REQUEST	Current Zoning: I-2, general industrial Proposed Zoning: TOD-MO, transit oriented development, mixed-use optional
LOCATION	Approximately 1.63 acres located on the southeast corner of South Mint Street and Lincoln Street.
CENTER, CORRIDOR, OR WEDGE	Corridor
SUMMARY OF PETITION	This request would allow a mix of retail, office, restaurant, and residential uses within two proposed buildings. The request proposes several options to the TOD.
STAFF RECOMMENDATION	The request is consistent with the <i>South End Transit Station Area Plan</i> , which recommends transit supportive development at this location. Staff feels with the addition of design elements for the deck along Lincoln Street the optional request is appropriate for approval if the outstanding site plan issues are addressed.
Property Owner	Asset Management 1, LLC and Vivace Enterprises, LLC
Petitioner	Asset Management 1, LLC
Agent/Representative	Stewart Engineering, Inc., Teresa Hawkins

PLANNING STAFF REVIEW

ILLUSTRATIVE SITE PLAN

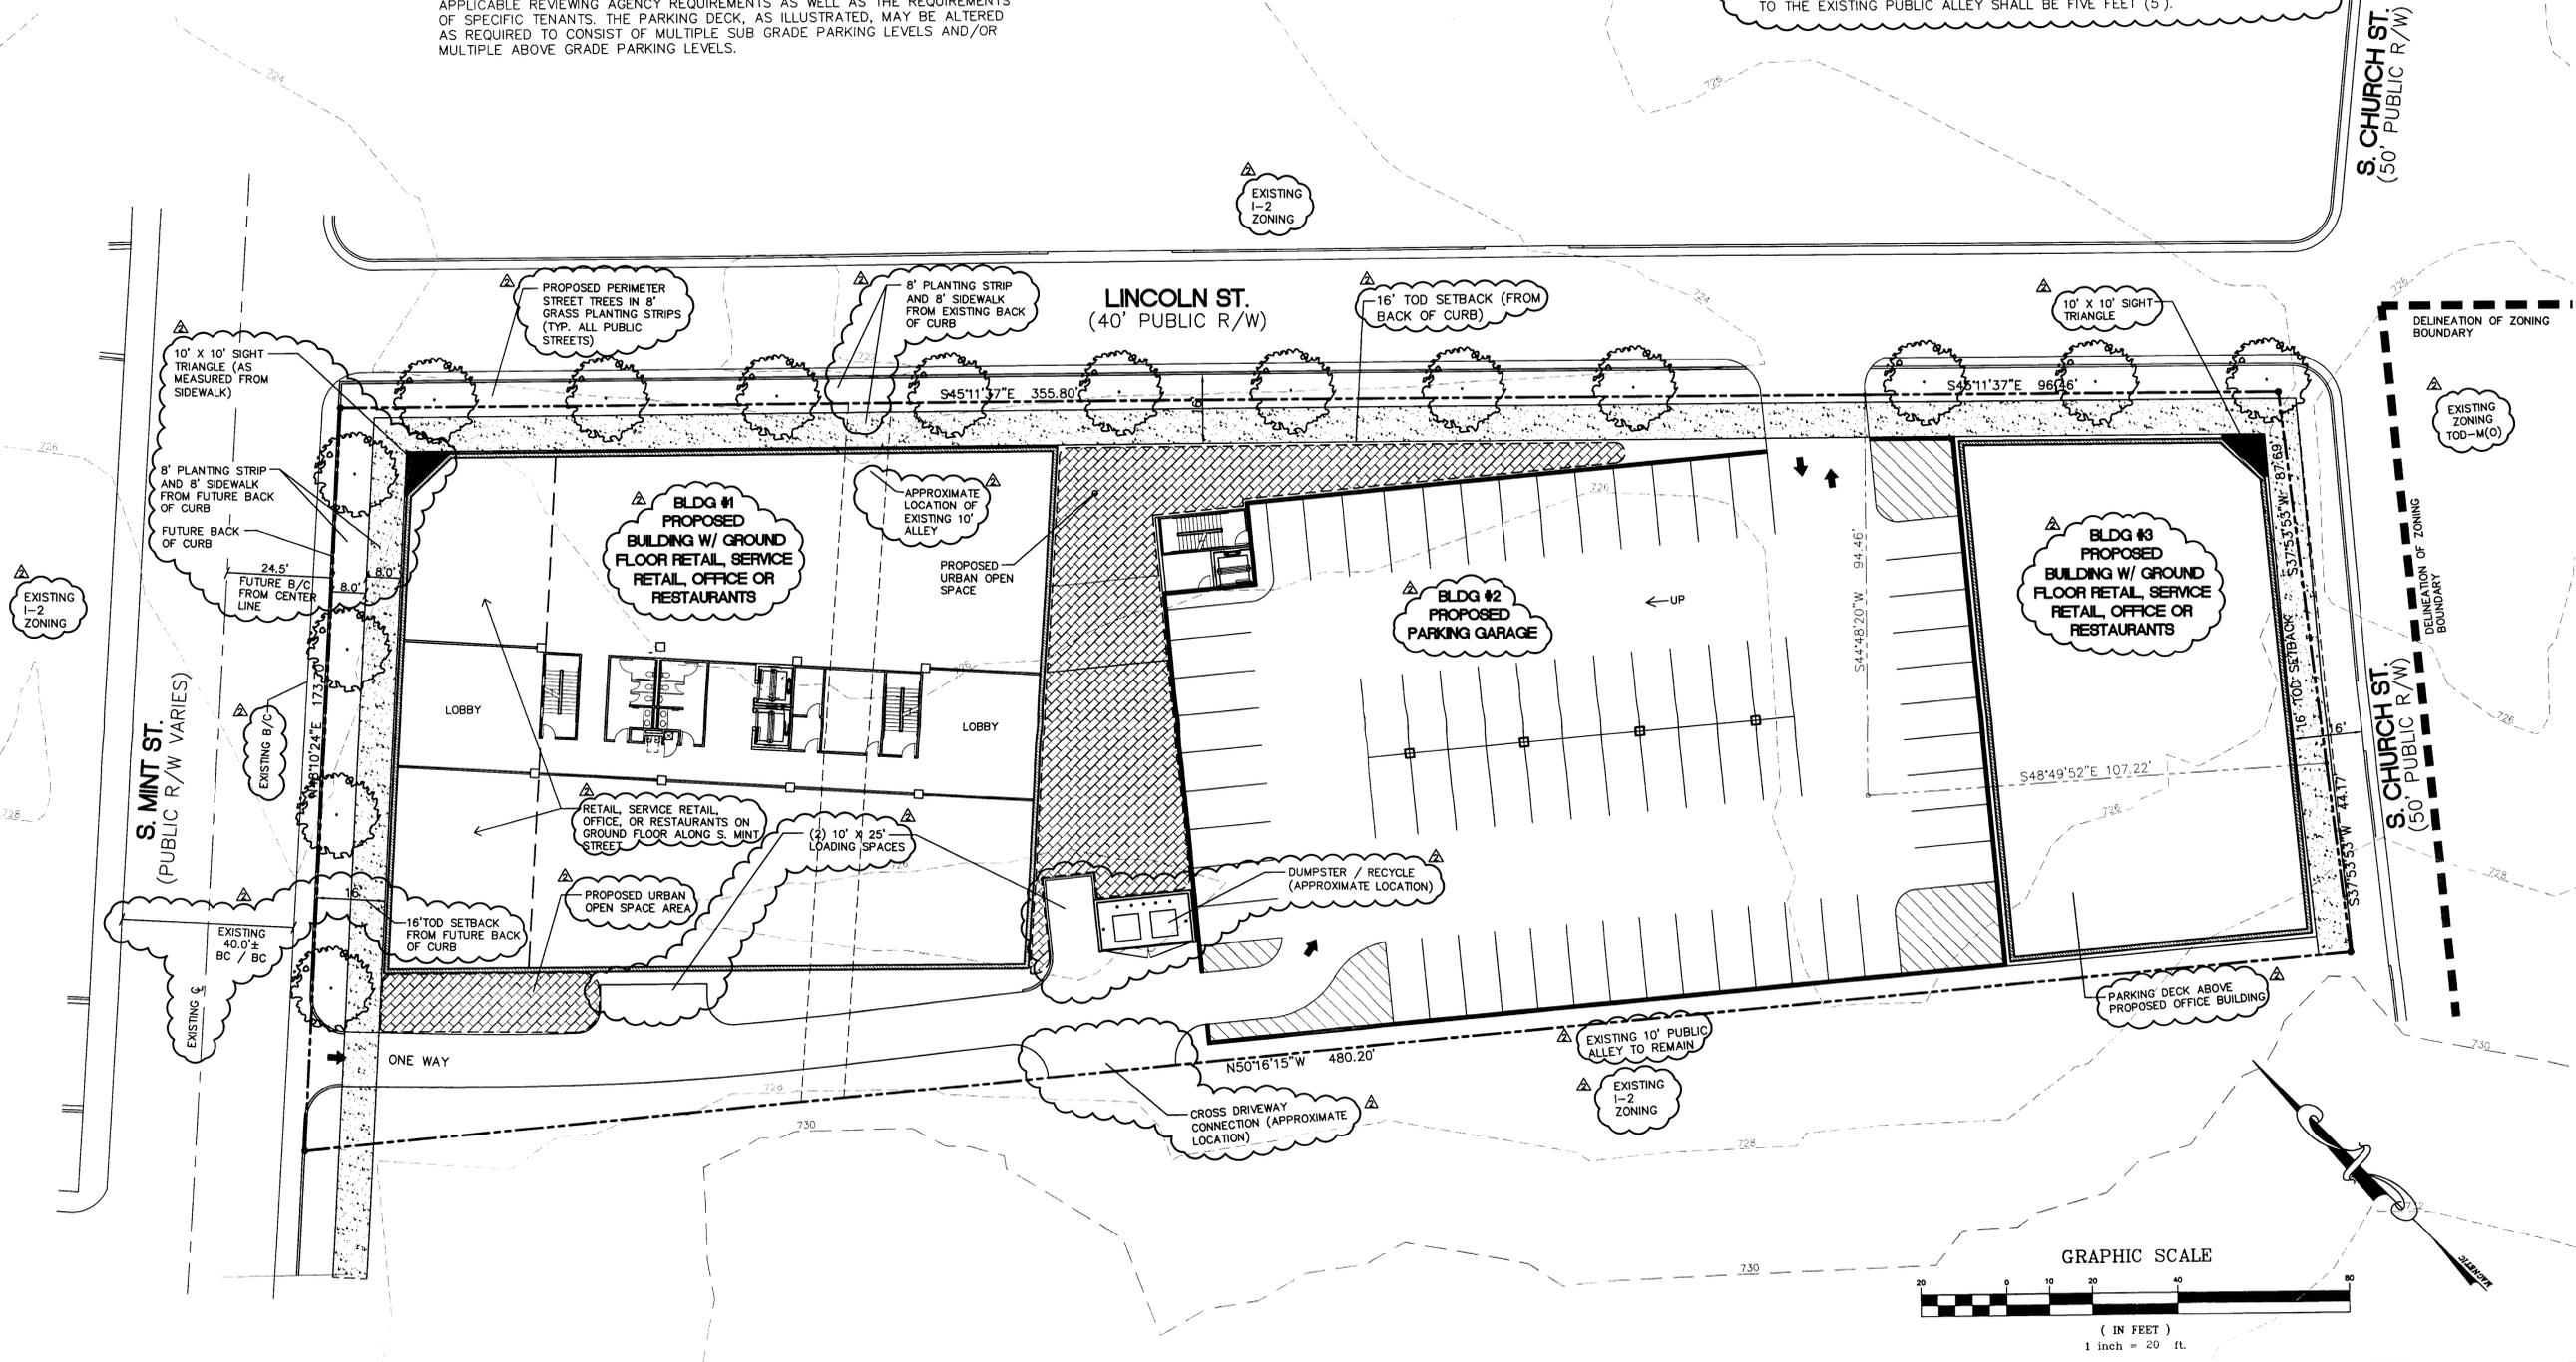
The parking deck will be designed with decorative architecture along Lincoln Street with materials that match the proposed buildings.

Open space will be provided between the deck and Lincoln Street.

- Elimination of retail, office, or residential uses along the linear street frontage of the parking deck.
- Increase in the width of the parking deck from an allowed maximum of 35% of the total lot width to 41.37% of the lot width. (This request should be removed as the 35% maximum applies to surface parking and not parking structures.)
- Establishment of a 5-foot rear setback along the southern alley. (This request should be removed as it complies with minimum ordinance standards).

- **CDOT:** In conformance with the *South End Transit Station Area Plan*, South Mint Street has an adopted new cross-section with a 49-foot back-of-curb width, which could require widening. The TOD setback will be measured from the back of this future curb line. See the online memo for additional comments.
 - **Charlotte Fire Department:** No issues.
 - **CATS:** No comments received.
 - **Connectivity:** A driveway connection will be provided to the south for a possible future cross access.
 - **Schools:** This non-residential request will not impact the school system.
-

1. The petitioner should remove the request to allow the parking deck to cover 41.37% of the lot width. (This request should be removed as the 35% maximum applies to surface parking and not parking structures.)
 2. The petitioner should remove the option to establish the 5-foot yard as it is a minimum ordinance requirement.
 3. The petitioner should address LUESA comments.
-
